Application H09-0430-16
Location Land off Penny Hill Road Holbeach Spalding
Proposal Residential development of 44 dwellings

Name Glen Chapman
Address Environmental Services

Site Layout 1:500

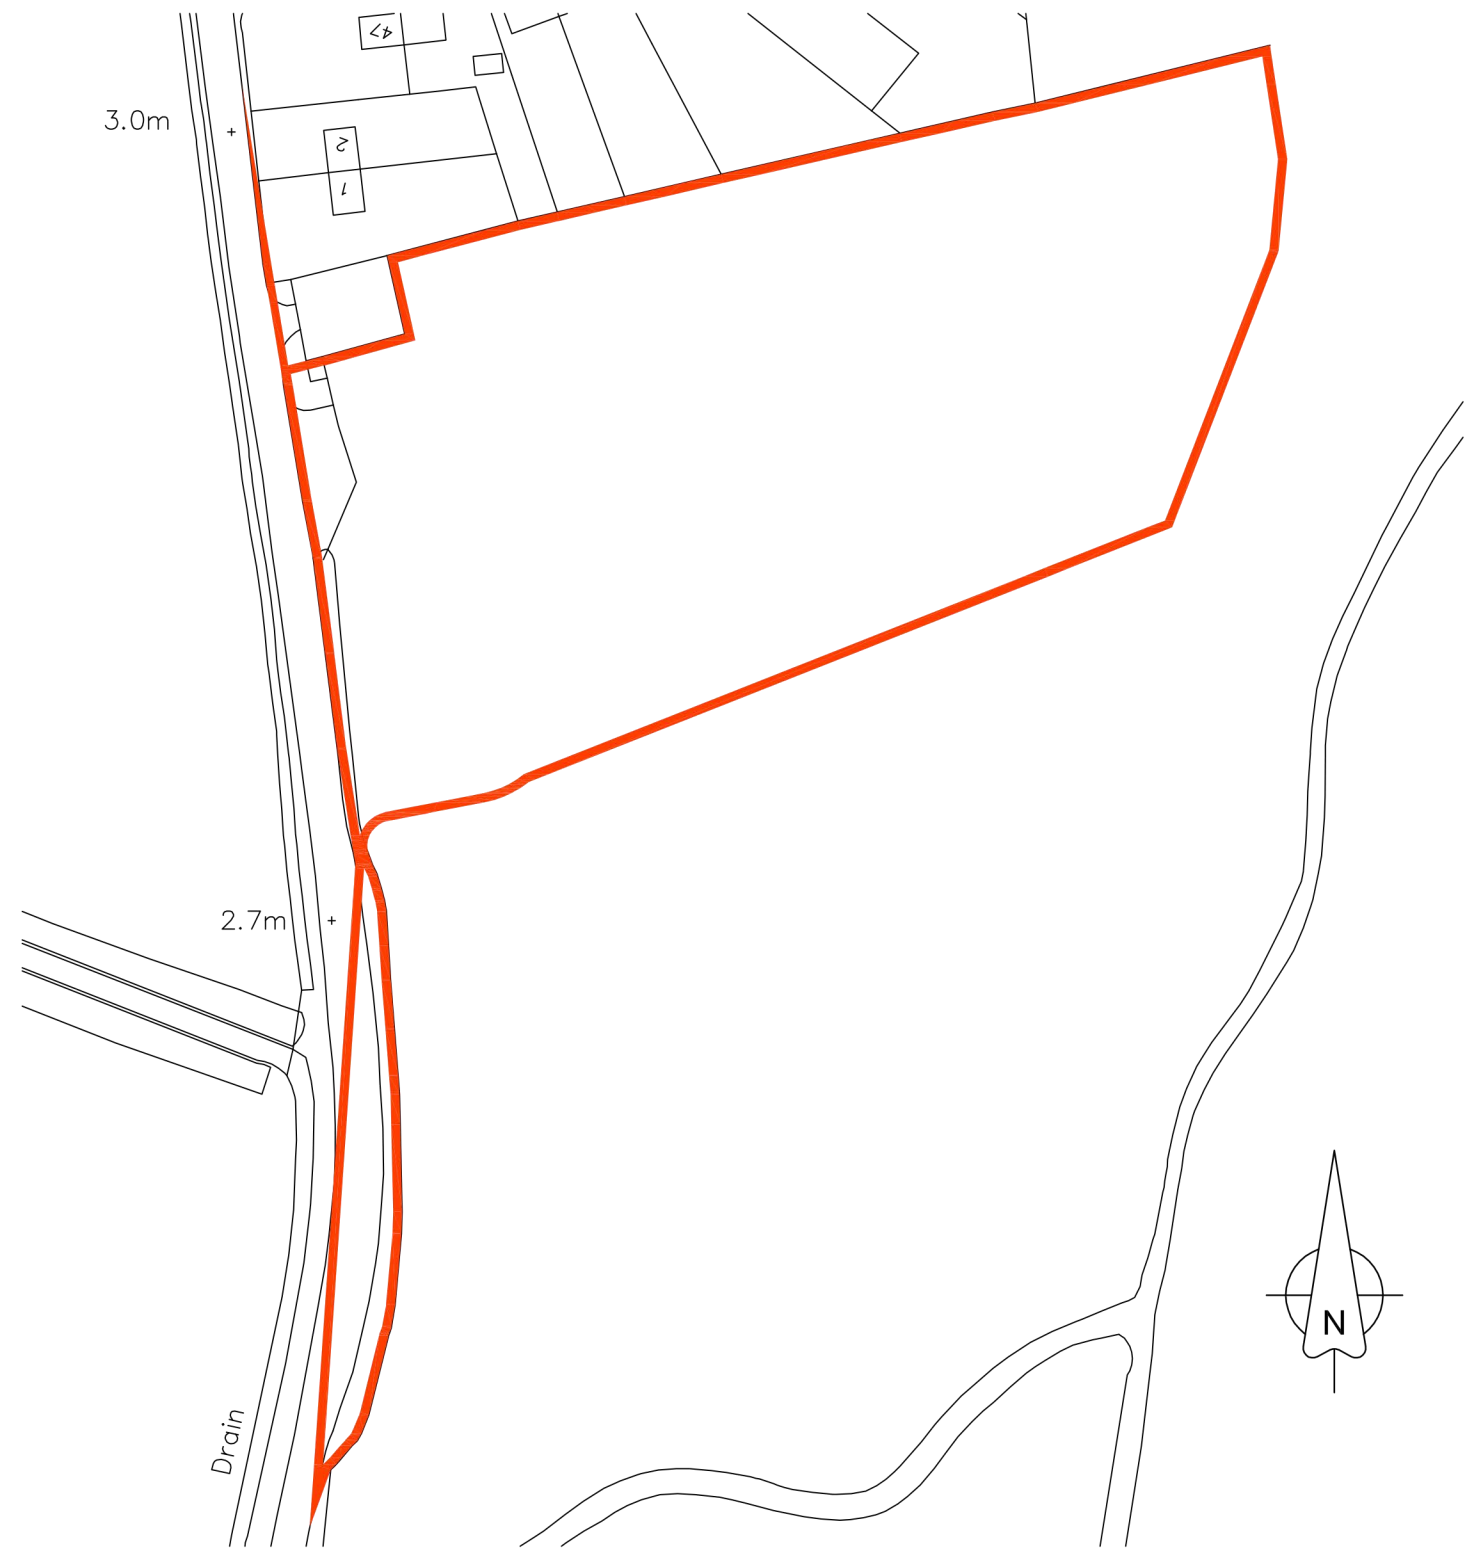
Access roadways to residential properties should be constructed to an adoptable standard under an agreement with Lincolnshire County Council so that they will become public highways. This will enable refuse/recycling collections to be carried out from outside individual properties without the need for communal collection points.
If not utilised correctly communal collection points become areas of dispute for residents of adjacent properties.
Should it be agreed that communal collection points will form part of this development the position of those collection points should be made clear to the potential occupiers of the properties nearby. This should not just be to the properties that will need to use the collection points but also the ones who will have them outside their properties.
